M25 junction 28 improvement scheme

TR010029

9.104 Applicant's comments on Grove Farm's Deadline 6 submission

May 2021

**Fig 3.1 - HE Indicative alignment of amended Grove Farm egress (Change 8)**

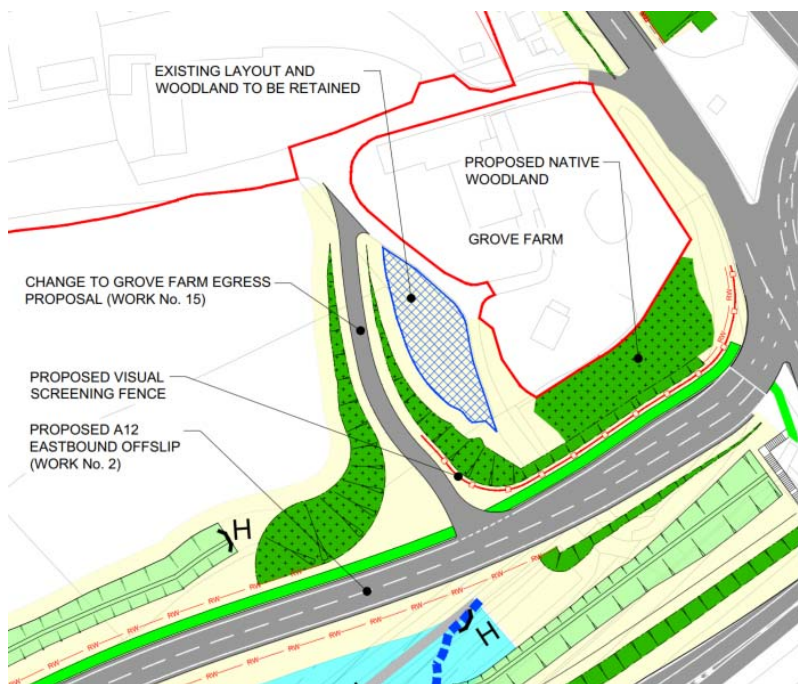
REP6-041-13	3.2 Grove Farm welcomes the response from HE with regards alteration of the farm egress onto the A12 eastbound off-slip, however a number of concerns remain: i) Proposals for Change 8 should be developed with Grove Farm on a topographical survey base not an ordnance survey base so that the full impact of proposals can be adequately reviewed. The request for topographical survey plans have previously been made;	The Change 8 proposals have been developed using a topographical survey base and Highways England is content to provide Grove Farm with the relevant drawings in PDF form. This plan has been provided to Grove Farm.
REP6-041-14	ii) The Change 8 proposals identify a 'visual screening fence' along the boundary of the A12 eastbound off-slip. Grove Farm's Supplementary Representations No.2, Section 4.0 (Ref: PMcL/3396d3/April 2021) discussed the reasons why a 'visual screen' is not acceptable to Grove Farm. The Scheme provides the only opportunity to enhance the environment of Grove Farm and partially mitigate the detrimental effects of the Scheme on Grove Farm. The provision of a noise attenuation barrier instead of a 'visual screen' fully supports HE's own goal to enhance the environment for people living and working close to the HE network and not just retain a detrimental status quo;	Highways England is taking the steps that are appropriate and proportionate to address the environmental effects of the Scheme on Grove Farm. A change request for the egress of Grove Farm is being submitted at Deadline 7 (TR010029/EXAM10.17 – Report and TR010029/EXAM/10.18 – Drawings) as well as the provision of visual screen fencing and additional planting. The provision of permanent noise barriers at Grove Farm, at considerable expense to the public purse, cannot be justified on the basis of the results of the noise assessment undertaken, which shows that change in noise at Grove Farm are negligible. The proposed visual screening of traffic by the fence is likely to help reduce psychological awareness of the traffic, and the reduced awareness may lead to perceptions of improved noise conditions, even if there were no change in noise levels. The Scheme will improve traffic flows through the junction and should reduce queuing at the junction in the vicinity of Grove Farm which will be beneficial to the owners of Grove Farm and together with the proposed visual screen fence and planting, the Scheme provides enhancement to the environment of Grove Farm.

**Figure 3.2 – Grove Farm's suggested location for extra noise attenuation fencing**

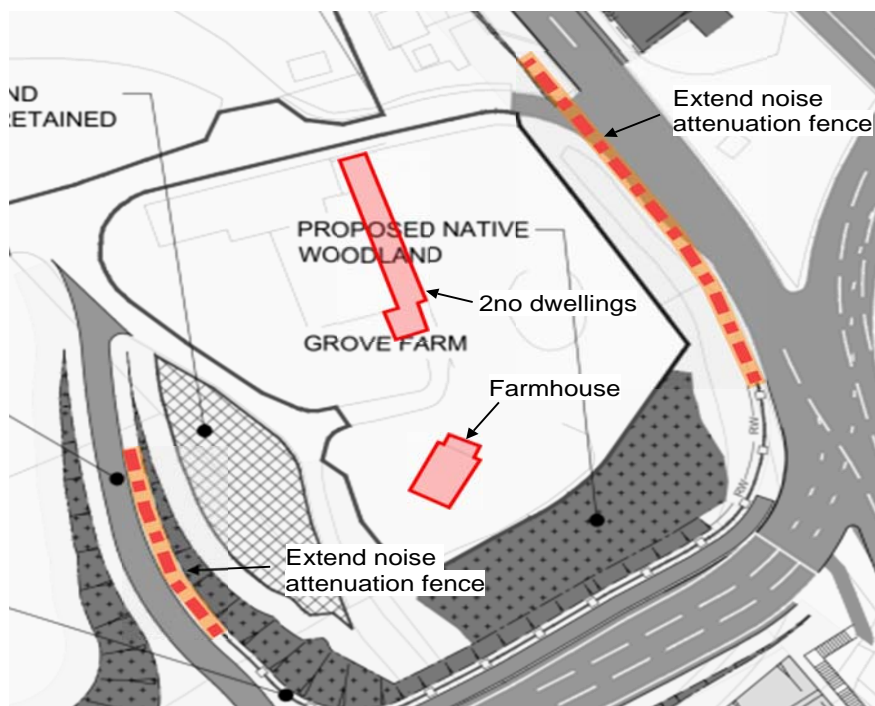
REP6-041-17	<p>v) The re-alignment of the A12 eastbound on-slip will relocate traffic flows closer to existing dwellings. A noise attenuation barrier should be extended into the site at the site egress as shown on Fig 3.2:</p> <p>Figure 3.2 – Grove Farm’s suggested location for extra noise attenuation fencing</p> 	<p>Highways England have estimated the performance of a 2m noise barrier along the A12 Eastbound off-slip around to the Grove Farm entrance. A noise barrier in this position would change the overall noise levels at Grove Farm by less than half a decibel. The noise levels at Grove Farm are dominated by the traffic on the M25 carriageway, which would not be screened by a barrier in this location. The overall impact of the Scheme would remain negligible if a noise barrier were to be constructed in this location.</p> <p>If a barrier were to be erected in this location, extending it along the Grove Farm egress would make no difference to the results because the extension to the barrier would not interrupt the line of sight between Grove Farm farmhouse and the A12 slip road.</p> <p>If a barrier were to be erected in this location, extending it along the M25 slip road would make a small difference to the results at Grove Farm, because the mainline M25 carriageway remains elevated above the junction. Highways England would expect that changes in noise as a result of the Scheme would remain negligible with any of the barrier options suggested by the representatives of Grove Farm.</p>

REP6-041-18	<p>3.3 In conclusion, Grove Farm requests that the ExA should direct the HE to provide a noise attenuation barrier instead of the ‘visual screen’ currently proposed and extend the noise attenuation barrier further north on the M25 northbound on-slip and further north into the farm egress as shown on Fig 3.2.</p>	<p>See responses above.</p>
